From: Iain Osenton <iain.osenton@cherwell-dc.gov.uk>
Sent: 16 May 2022 15:50
To: Caroline Ford <Caroline.Ford@Cherwell-DC.gov.uk>
Cc: dcregistration <dcregistration@Cherwell-DC.gov.uk>
Subject: 21/04275/OUT - CDC Arboriculture

From desk based assessment.

At the outline stage the Arboricultural statement appears to highlight only BS5837:2012 category U trees for removal, along with sections of hedgerow for access. These hedgerow removals will need to be mitigated, I'd suggest through hedge improvement works to retained hedges once we reach the reserved matters stage.

drawing title
**TREE RETENTION PLAN
SOUTH**

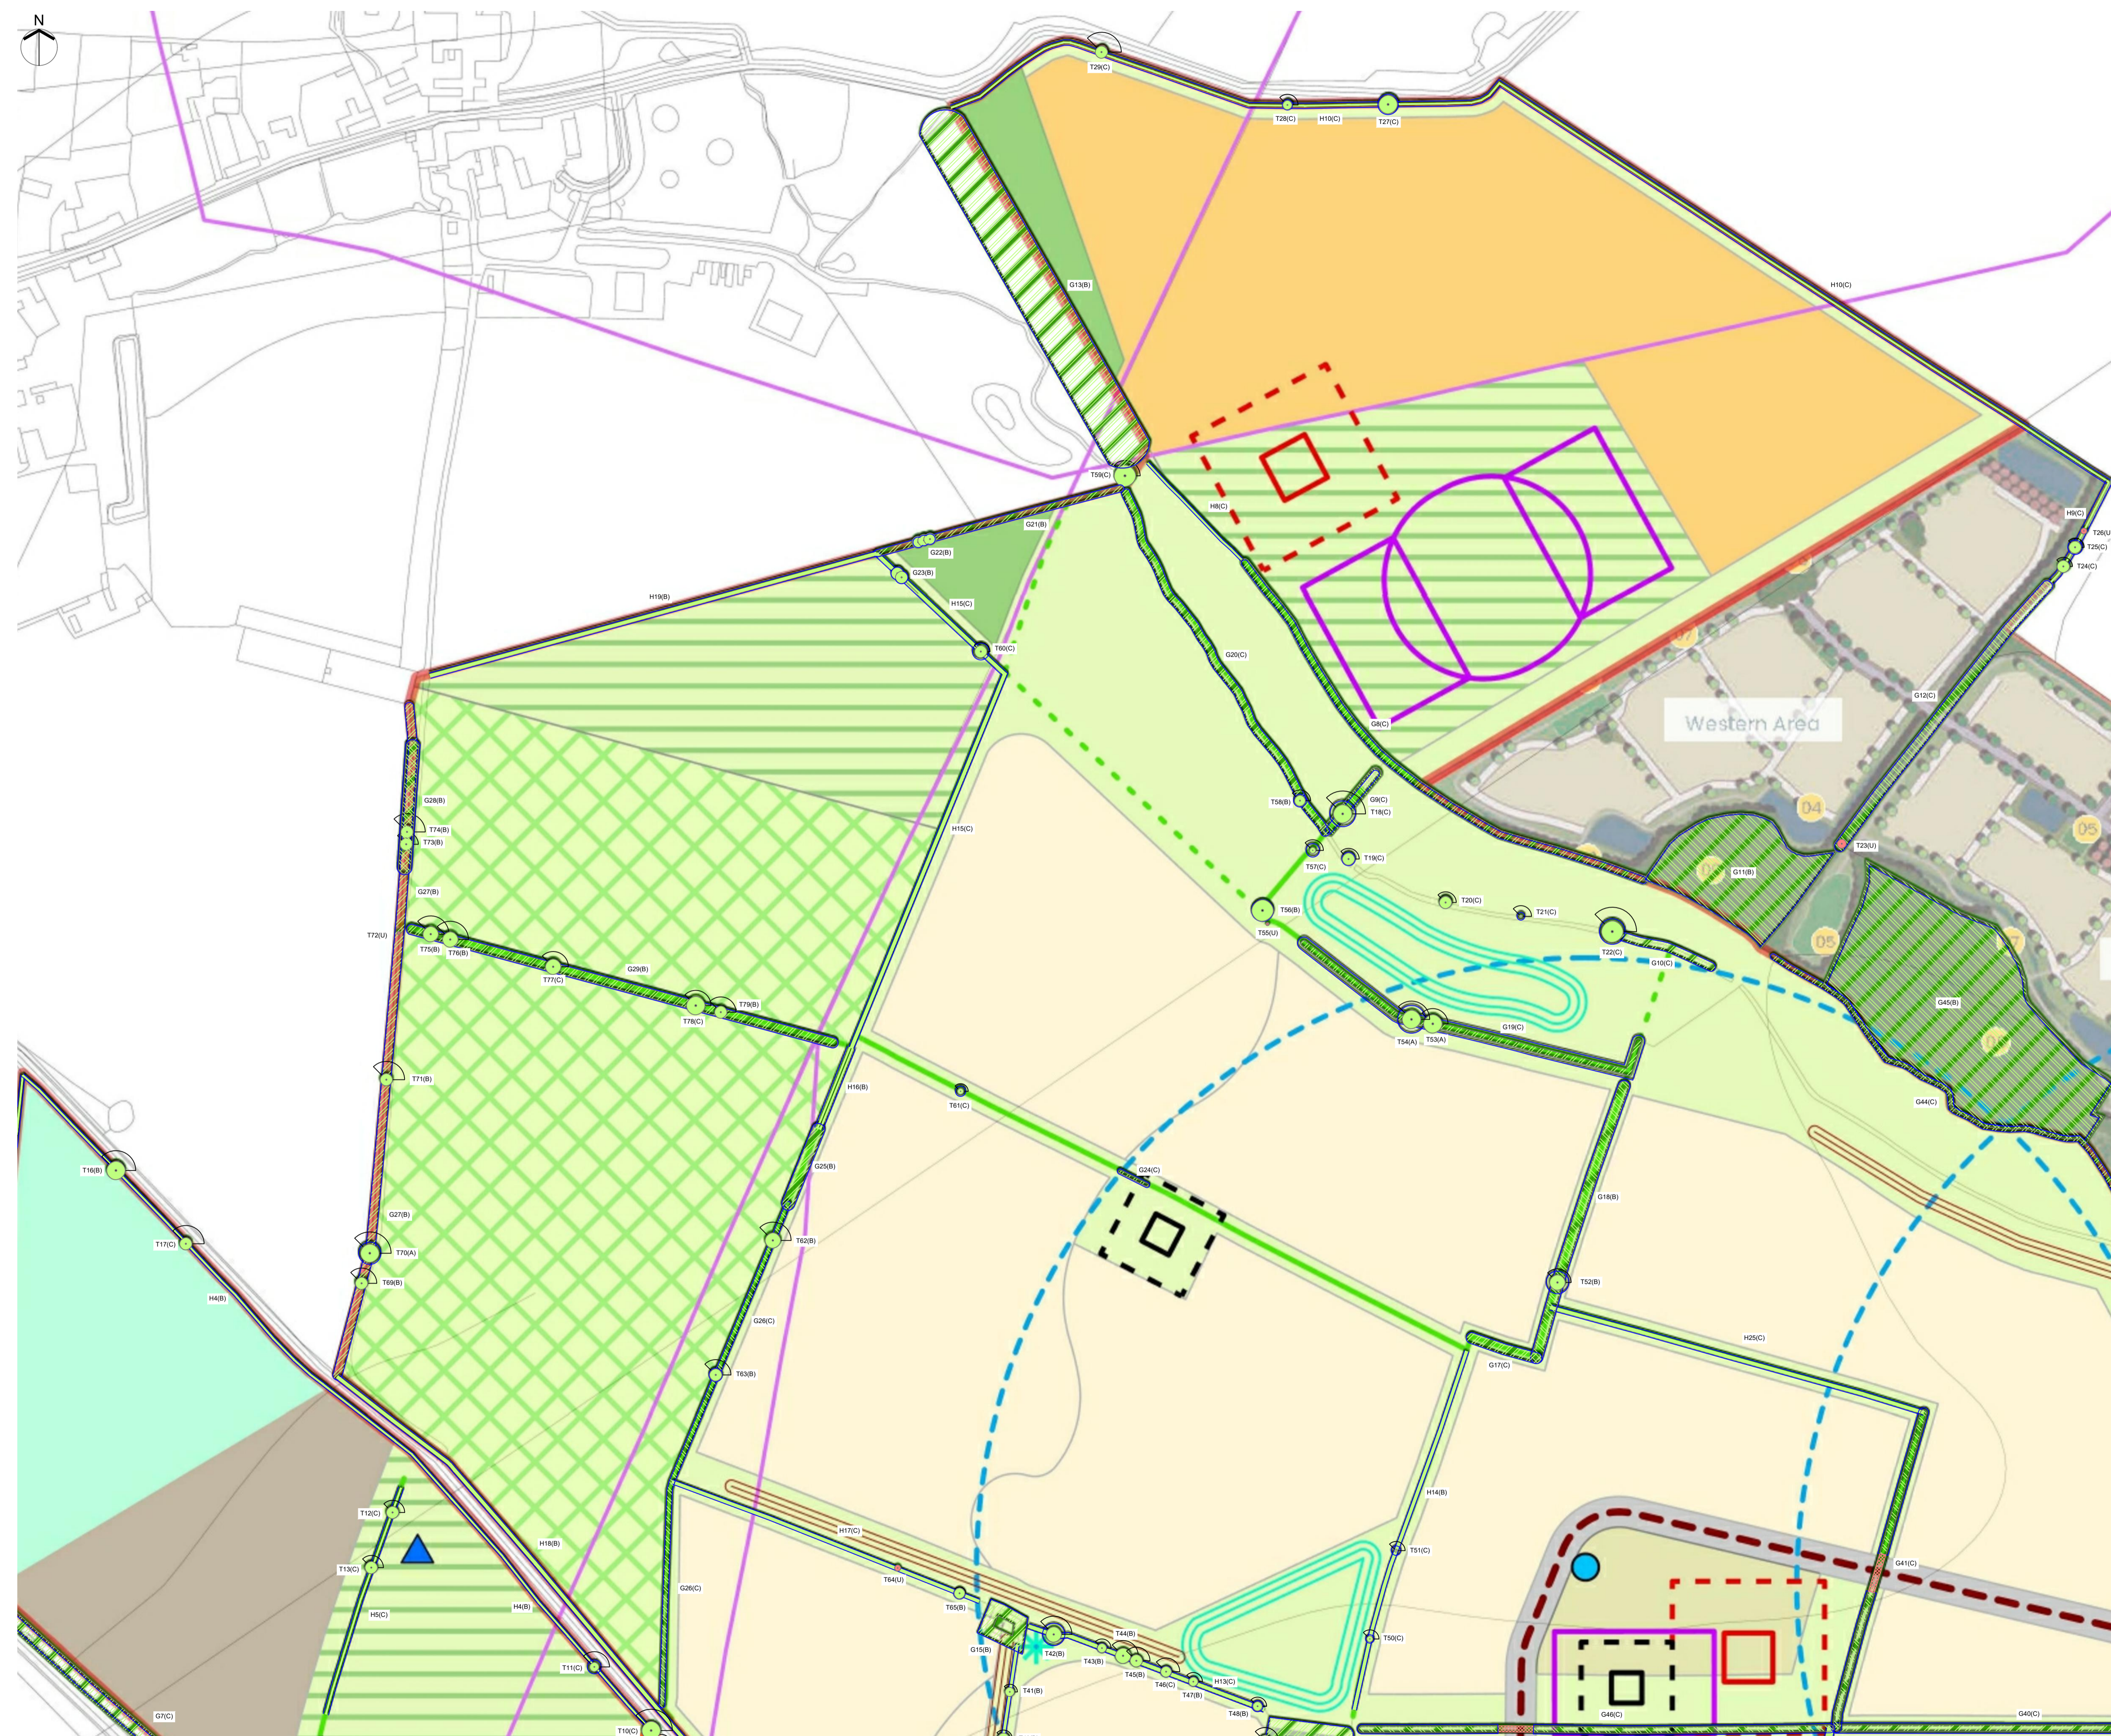
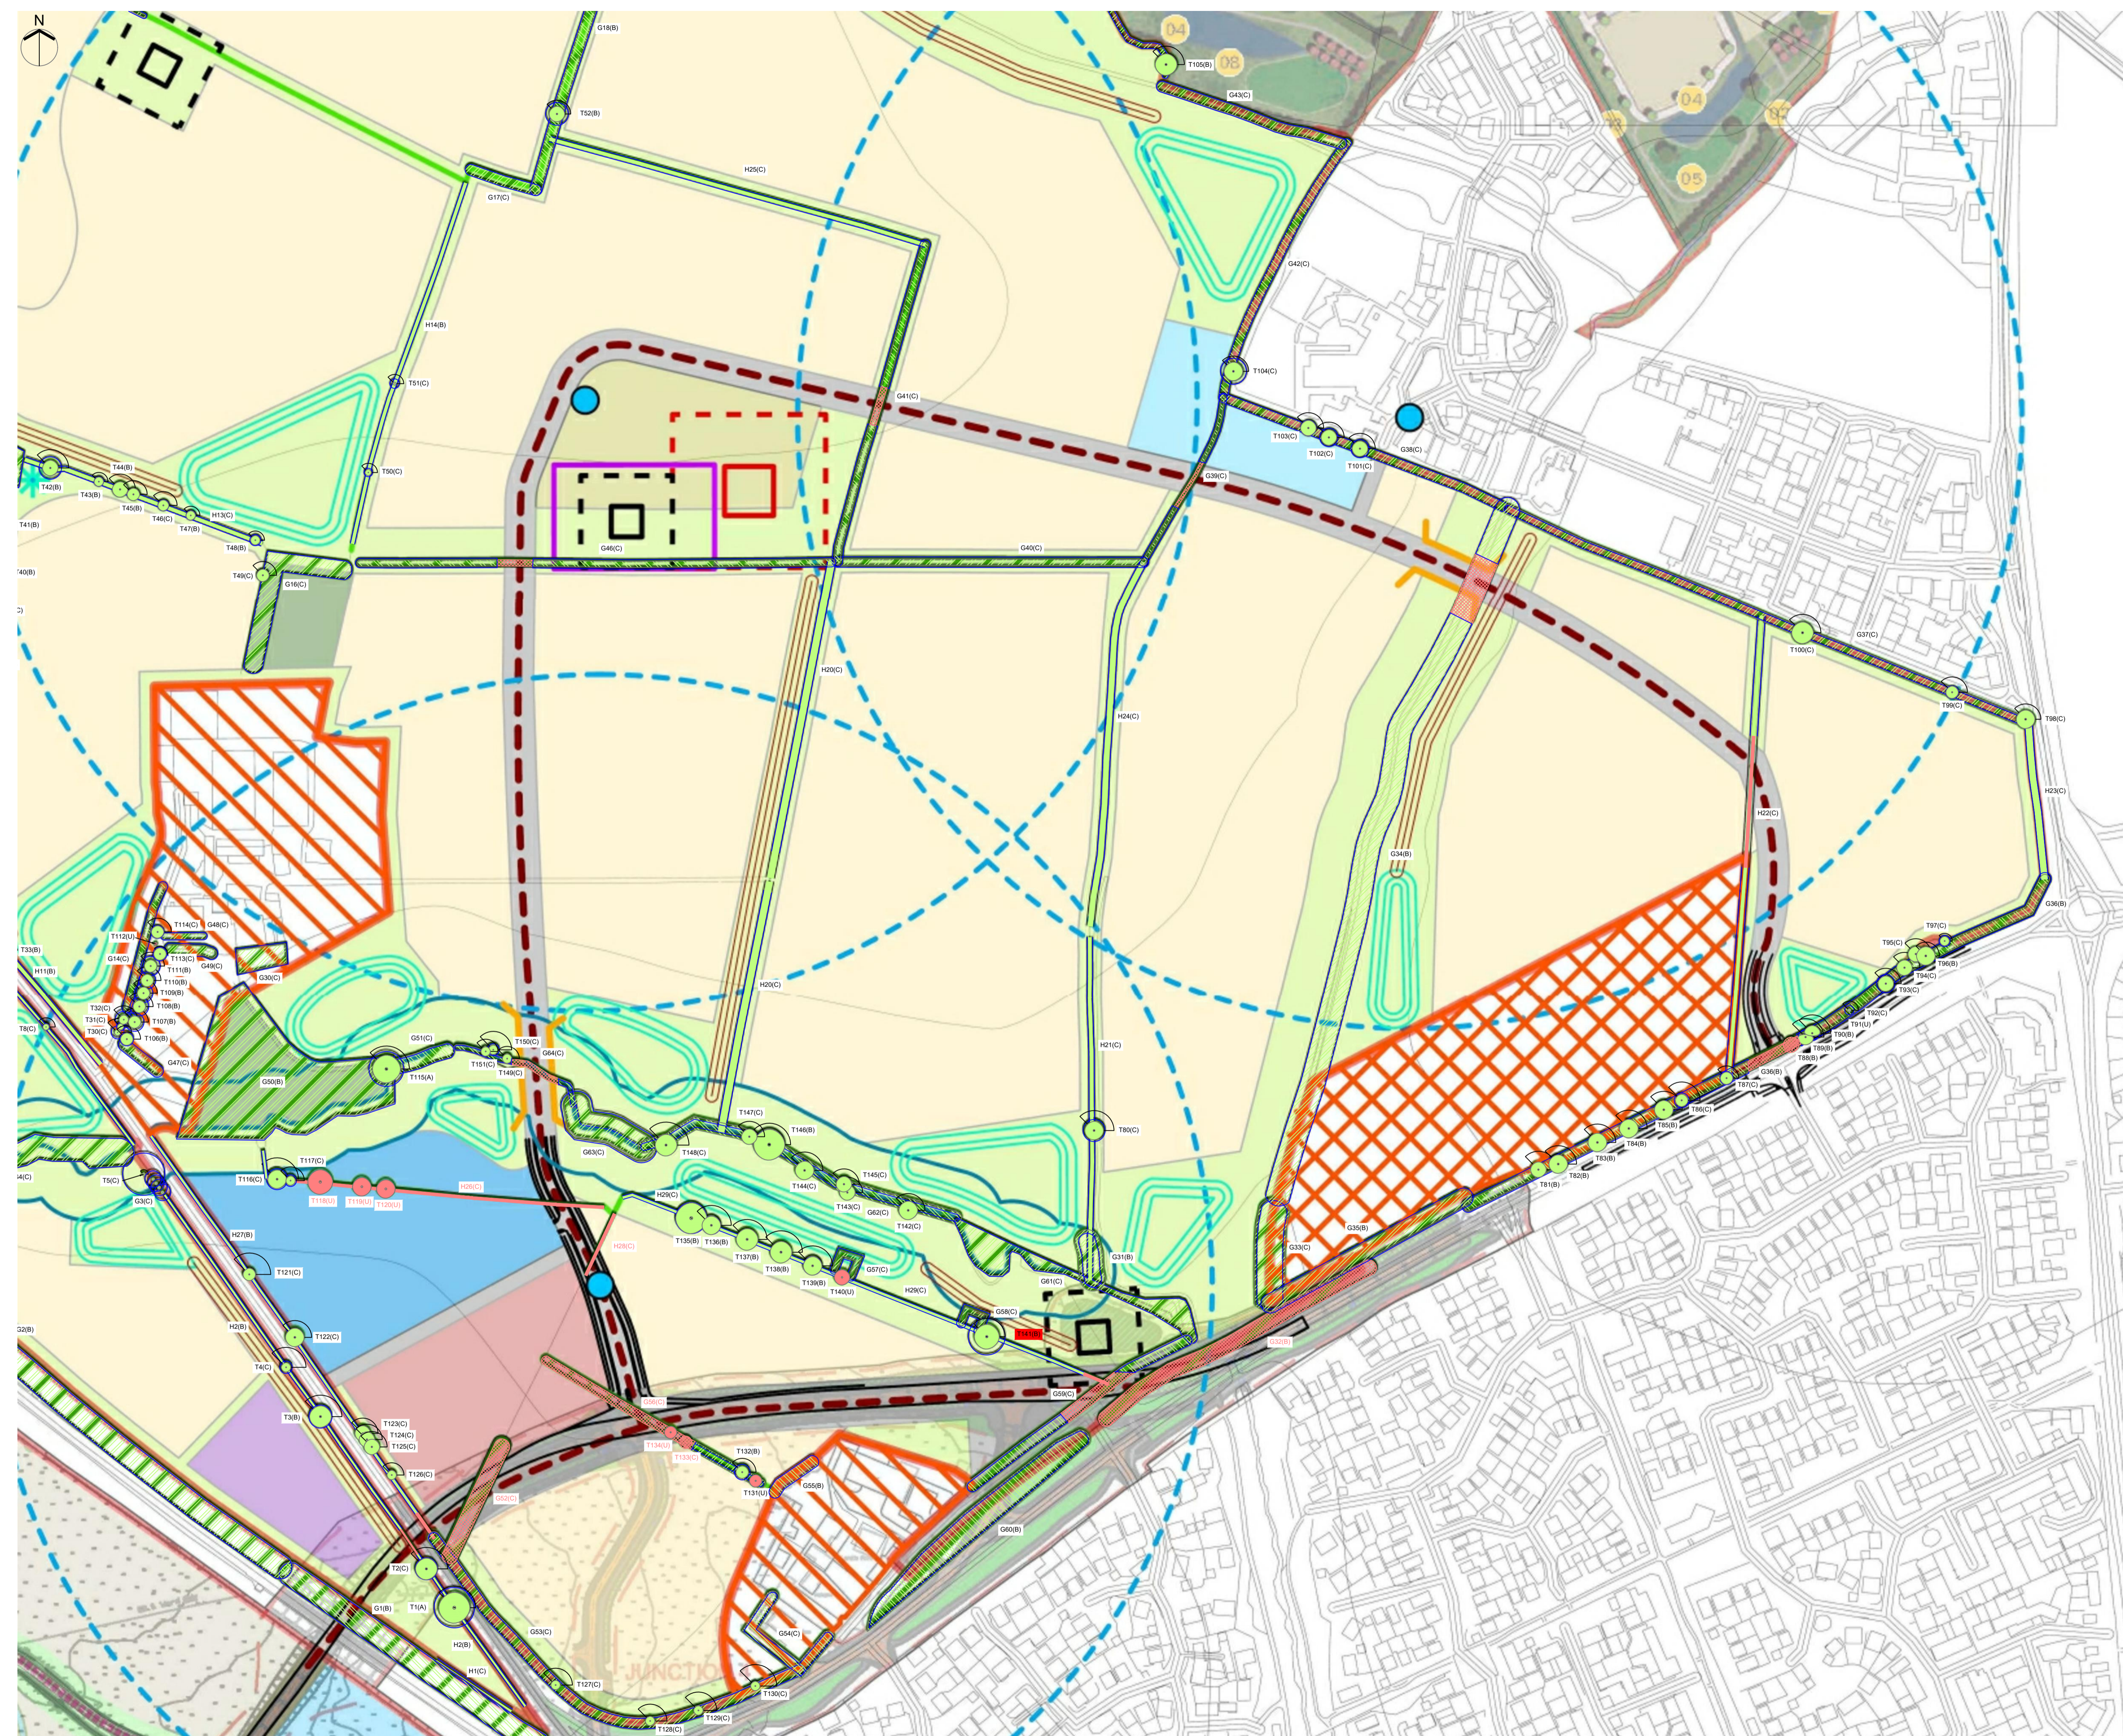
- A replanting/landscaping plan will also be required. Hedge improvement works will form valuable mitigation for hedge removals.
- The site contains numerous category A and B features. Layout should seek to work around these features to ensure their retention.

- Retention of hedges, higher quality trees, and protected trees will be aided by providing a buffer between development and retained features. Where possible retained features should be incorporated into sustainable locations, such as parks, green corridors etc.

- Trees and particularly hedges set for retention should consider buffer areas not only to aid retention but also for future maintenance. By comparison green corridors retained in Langford, Bicester, have done so with minimal space either side, creating conflict with properties, and maintenance access issues.

- Many category C features have cavities observed, where safe to do so the design should seek to retain these features. Veteran tree populations in the UK are declining faster than they are being replaced, consequently unique habitat is being lost. This development offers excellent scope to retain trees and hedges with excellent habitat properties. Arboricultural works may be required to allow retention of some features.

- The site contains numerous ash trees. An ash dieback condition survey should be submitted at the reserved matters stage as trees previously marked for retention may require removal, and subsequent replanting.
